From: PETER SHAW [REDACTED]
Sent: 30 March 2022 13:04
To: Harry Chalk <Harry.Chalk@arun.gov.uk>
Subject: Re: FW: R/18/22/HH, 7 Evelyn Avenue
Importance: High

I have noticed that on the proposed plans for the above application, there is a single storey side and rear extension, but there also appears to be some alterations to the garage roof. Are these to be a part of the application? If so, and it is agreeable, could I request approval to amend the description to also include garage roof alterations? It would read 'Erection of single storey side extension, single storey rear extension and alterations to garage roof.'

Project: Proposed extensions; 7 Evelyn Avenue, Rustington BN16 2EJ	
Drawing: Plans and elevations as proposed	
For: Mr. & Mrs. A. Mullen-Orriss	
Drawn: PKS	Date: January 2022
Scales: 1:100 1:200	No: 2917/01/02
To scale when printed on A3

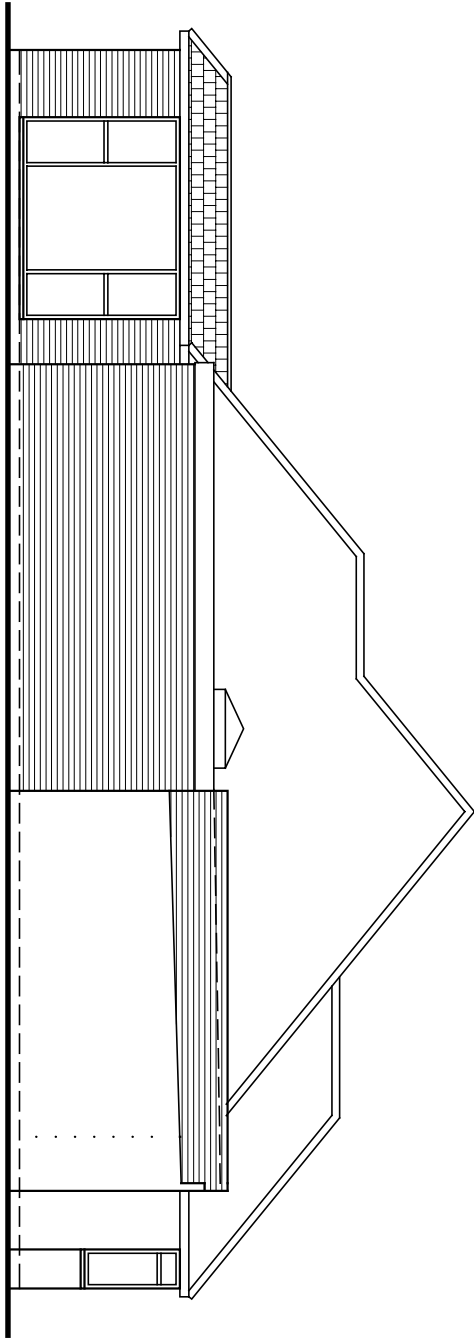
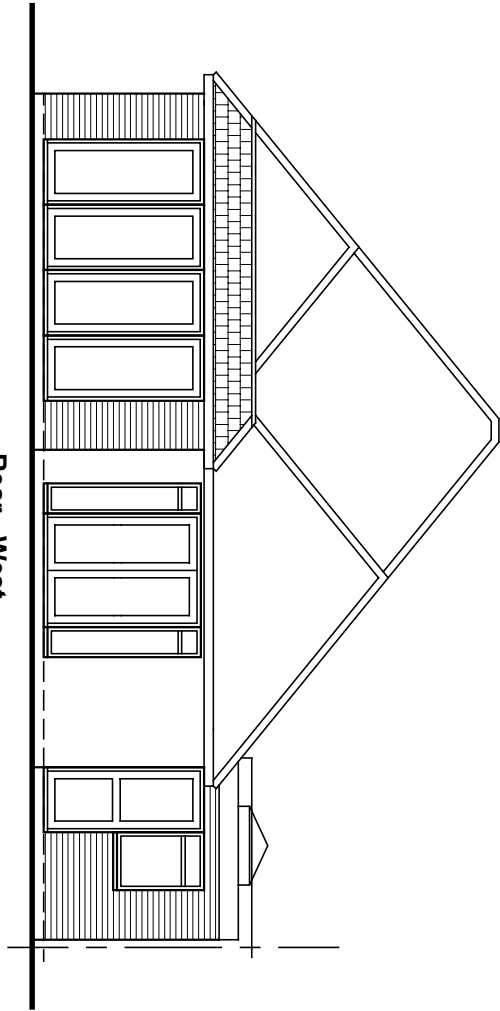
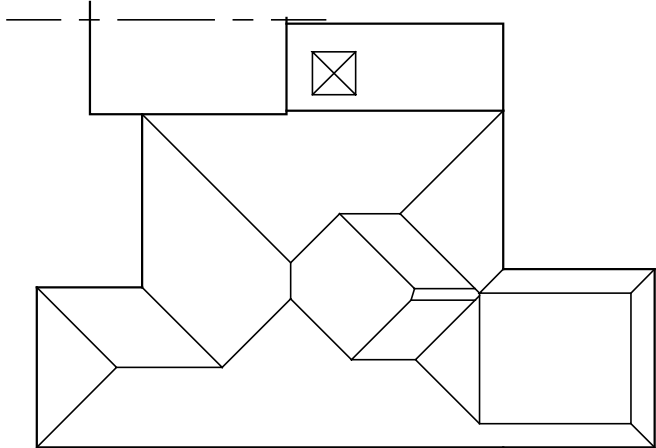
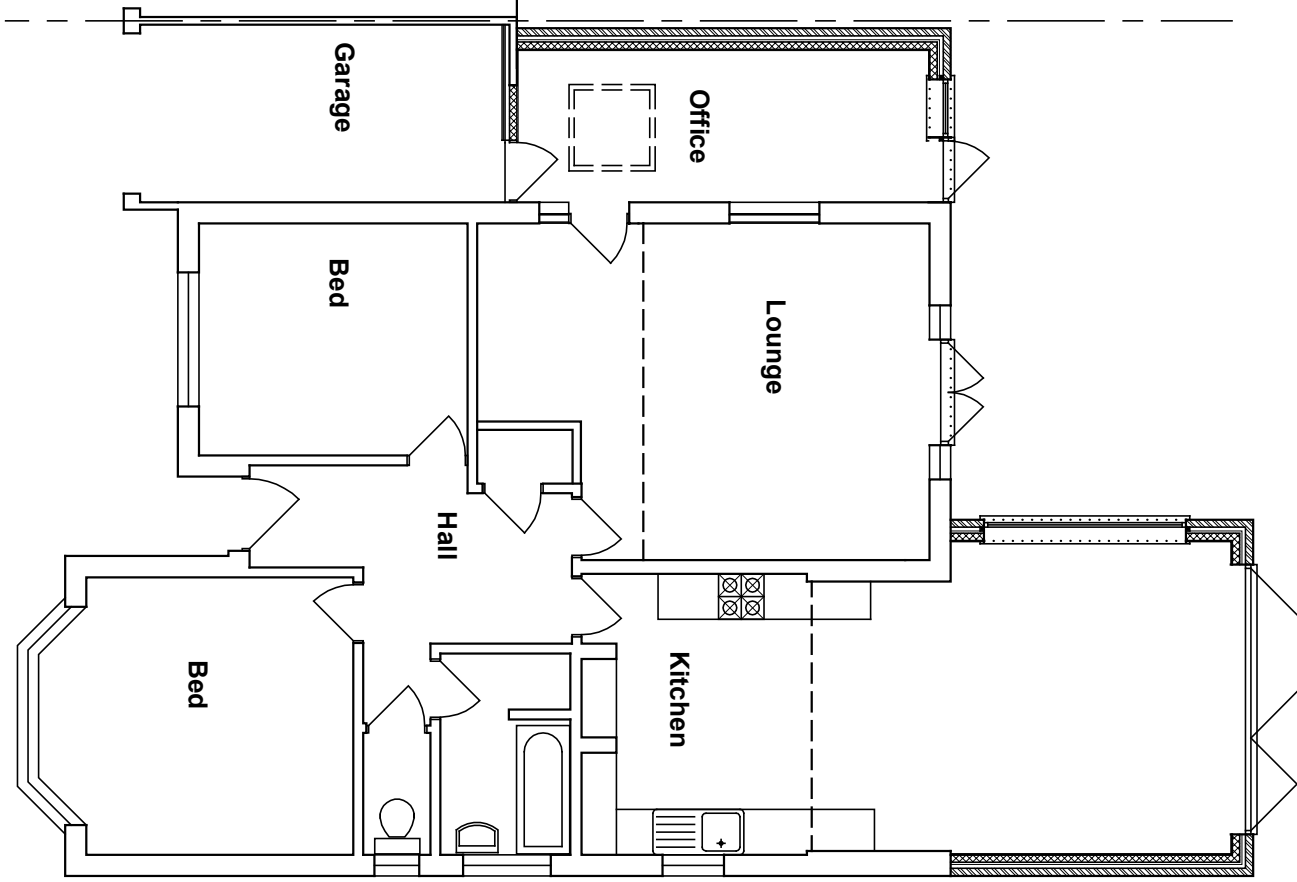
Could I also request some clarification as to the proposed materials, I see that the application form makes reference to the drawings to clarify materials however, these only show the form of the external materials not what they are to consist of or their colour.

Sorry for the tardy reply. I agree to the amended description and attach a revised drawing for the materials.
